An
Bord
Pleanála

Inspector's Report ABP-318223-23

Whether the construction of a conservatory, 3 no. structures and an access track is or is not development and is or is not exempted development.

Lettergesh East, Renvyle, Co. Galway

Manufacturers dimensioned drawing of new conservatory

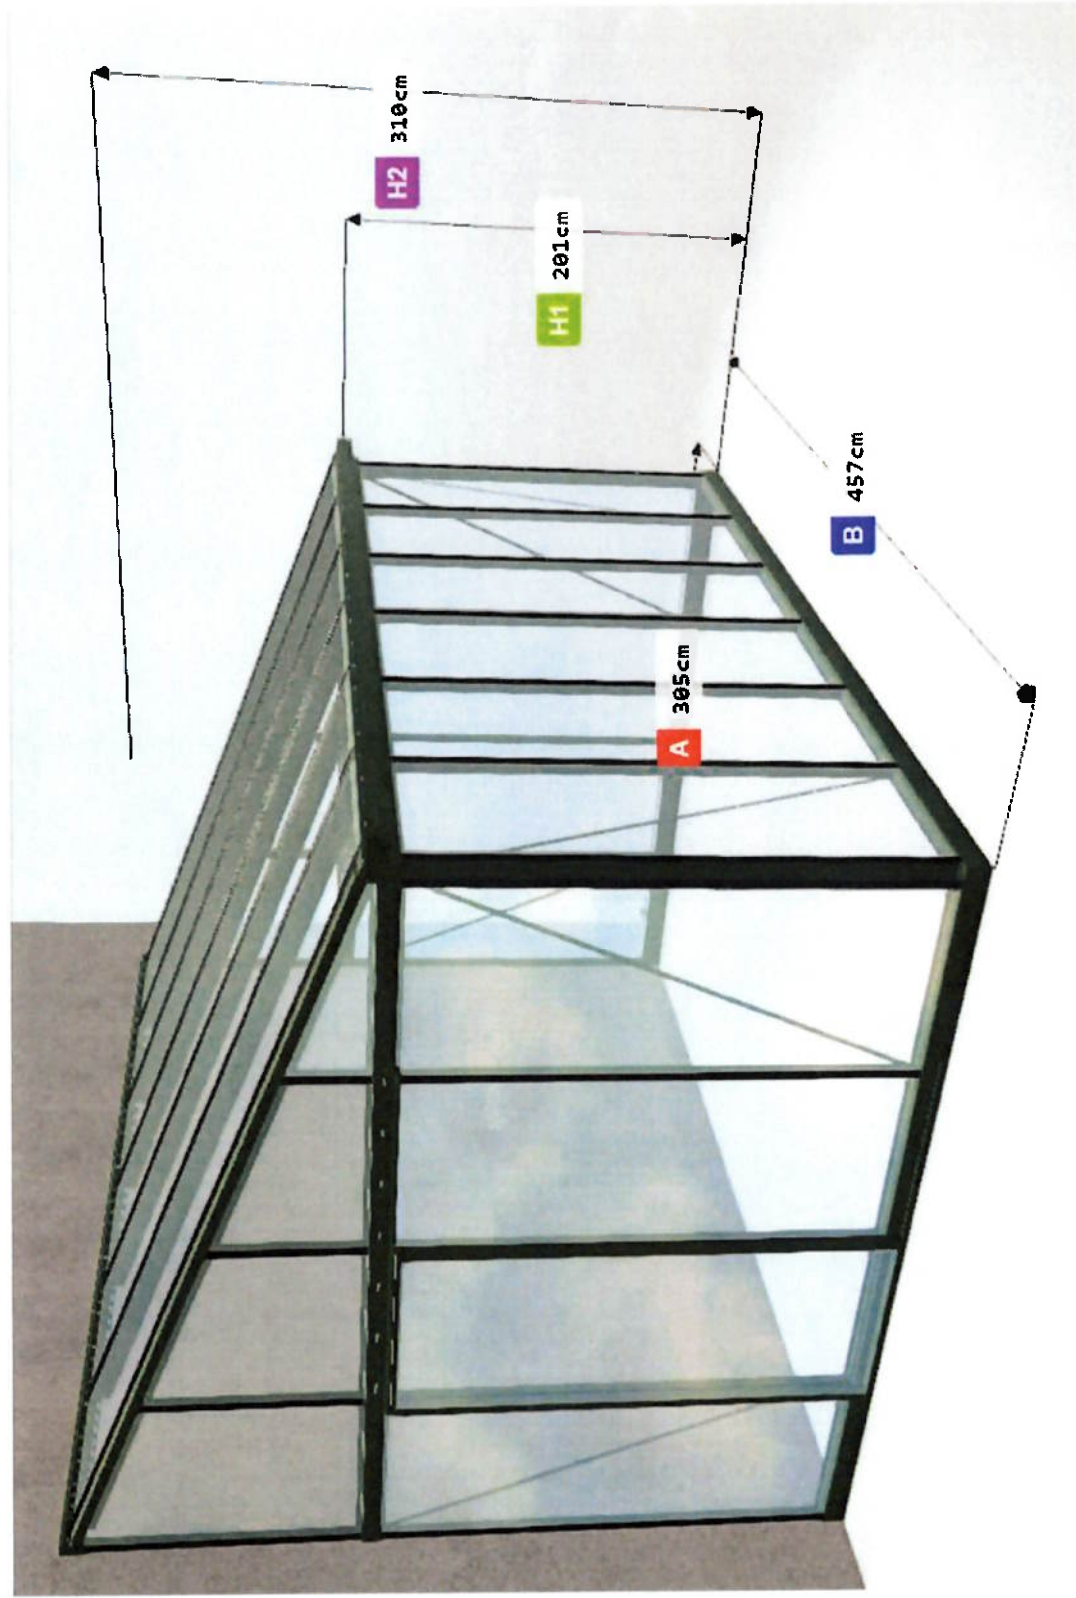
8.4.2. **Conservatory** – the conservatory attached to the side/southern elevation of the dwelling is stated as replacing a previous ‘lean-to’ type structure (photographs and a floor plan of same are provided in referrer’s submission). The floor plan indicates dimensions of 4.5 metres (L) x 3 metres (W), giving a floor area of c. 13.5 sqm. The structure has a maximum height of 3.1 metres. Class 1, Part 1, Schedule 2 of the Planning and Development Regulations 2001, as amended, provides that development within the curtilage of a house comprising the extension of a house, by the construction or erection of an extension (including a conservatory) to the rear of the house or by the conversion for use as part of the house of any garage, store, shed or other similar structure attached to the rear or to the side of the house⁶. As the conservatory replaces an lean-to structure I consider that it falls within the description of ‘the conversion for use as part of the house of any garage, store, shed or other similar structure attached to the rear or to the side of the house’. To avail of the exemption under Class 1, the proposal must comply with the conditions and limitations in Colum 2, listed 1 – 7. I note that the conservatory complies with the applicable conditions and limitations and in this regard I note the following;

- The conservatory is single storey.
- The floor area of the conservatory and the existing rear annex does not exceed 40 sqm.
- The height of the conservatory does not exceed the rear wall of the house, and the height of the highest part of the roof of the conservatory does not exceed the highest part of the house.

- The conservatory is located to the side of the house and does not affect private open space to the rear of the house.
- The conservatory is situated in excess of 1 metre from the opposing site boundary.
- The roof of the conservatory is not used as a balcony or roof garden.

I consider that the conservatory comes within the scope of the exempted development provisions of Class 1, Part 1, Schedule 2 of the Planning and Development Regulations, 2001, as amended and **is exempted development**.

Plan and elevation of the cottage showing then extent of work carried out in 2021/22.

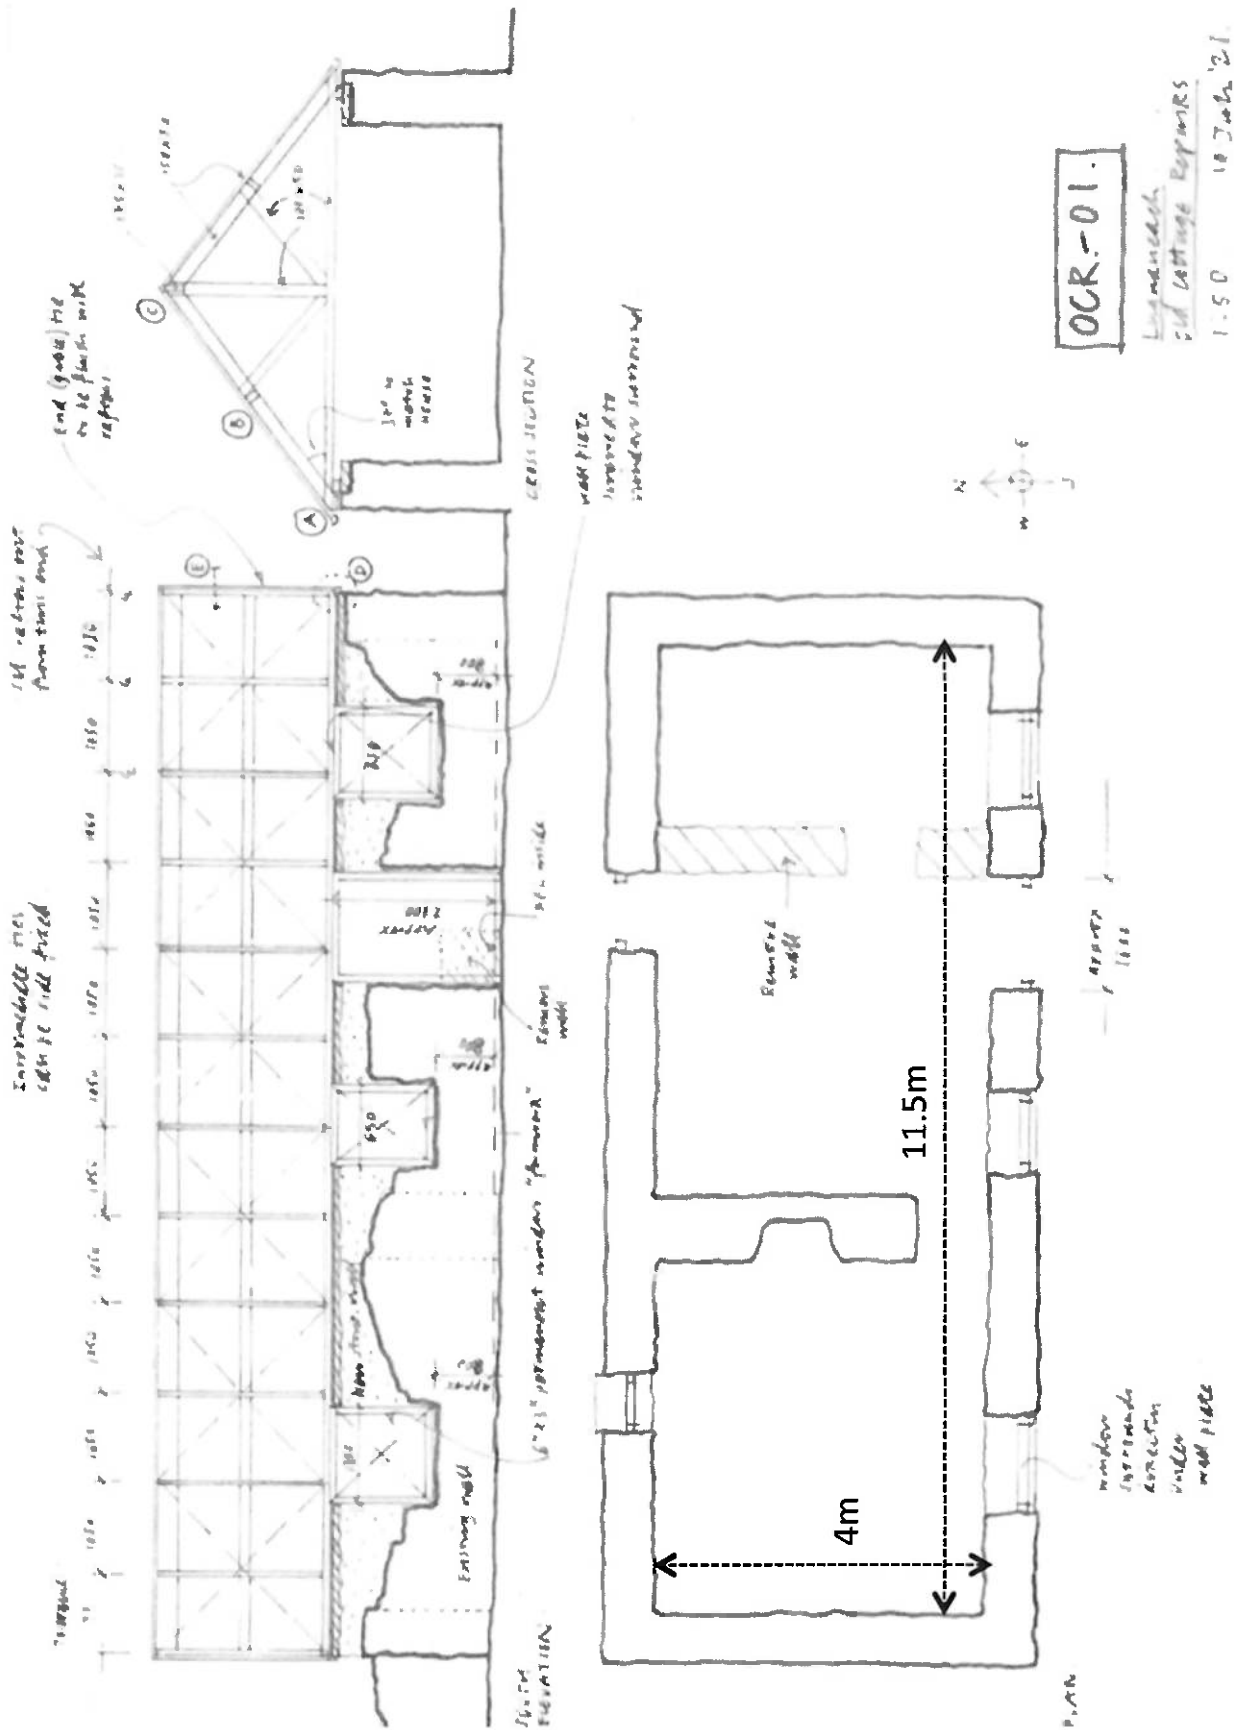
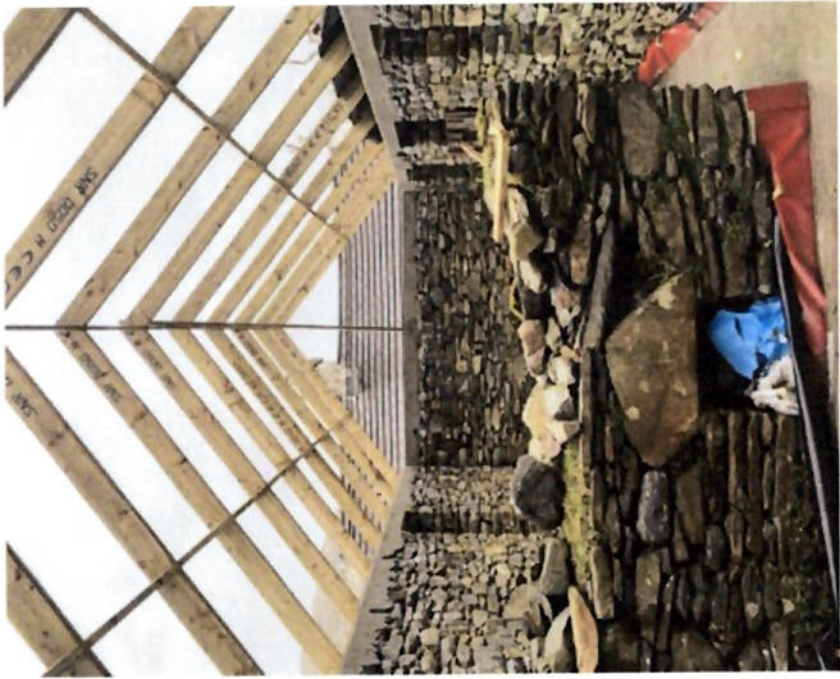
8.4.3. **Building up of external and internal walls, the removal of an internal wall, and the provision of a Perspex roof on a ruinous structure, previously used as a shed/cottage**

– the works undertaken to the structure indicated as ‘former cottage in ruin’ comprise the building up of the side wall of the structure as indicated on *Drawing No. OCR-01*, the removal of an internal wall and the provision of a Perspex pitched roof. The referrer contends that the provisions of Section 4 (1) (h) of the Planning and Development Act, 2000, as amended confer an exemption of these works. Section 4 (1) (h) provides for ‘*development consisting of the carrying out of works for the maintenance, improvement or other alteration of any structure, being works which affect only the interior of the structure or which do not materially affect the external appearance of the structure so as to render the appearance inconsistent with the character of the structure or of neighbouring structures*’. In my opinion the works to the external and internal walls of the structure would come under Section 4 (1) (h), being works for the improvement of the structure, and which in the case of the removal of the internal wall affect only the interior of the structure. The building up of the outer wall does not materially affect the external appearance of the structure, but rather provides for the restoration of the structure to its prior condition. The provision of the Perspex roof, whilst works for the improvement of the structure, would in my view be inconsistent with the character of the structure itself. Whilst I agree with the referrer’s contention that the roof of the original structure may have changed over time I note that the use of a modern material like Perspex would not have been used and is therefore inconsistent with the original design of the structure. Additionally, the

transparency of the material is in my opinion incongruous with the design idiom of the structure.

In summation, I consider that the building up of external and internal walls and the removal of an internal wall of the conservatory comes within the scope of Section 4 (1) (h) of the Planning and Development Act, 2000, as amended and **is exempted development**, but that the provision of a Perspex roof does not come within the scope of the exempted development provisions of Section 4 (1) (h) of the Planning and Development Act, 2000, as amended and **is not exempted development**.
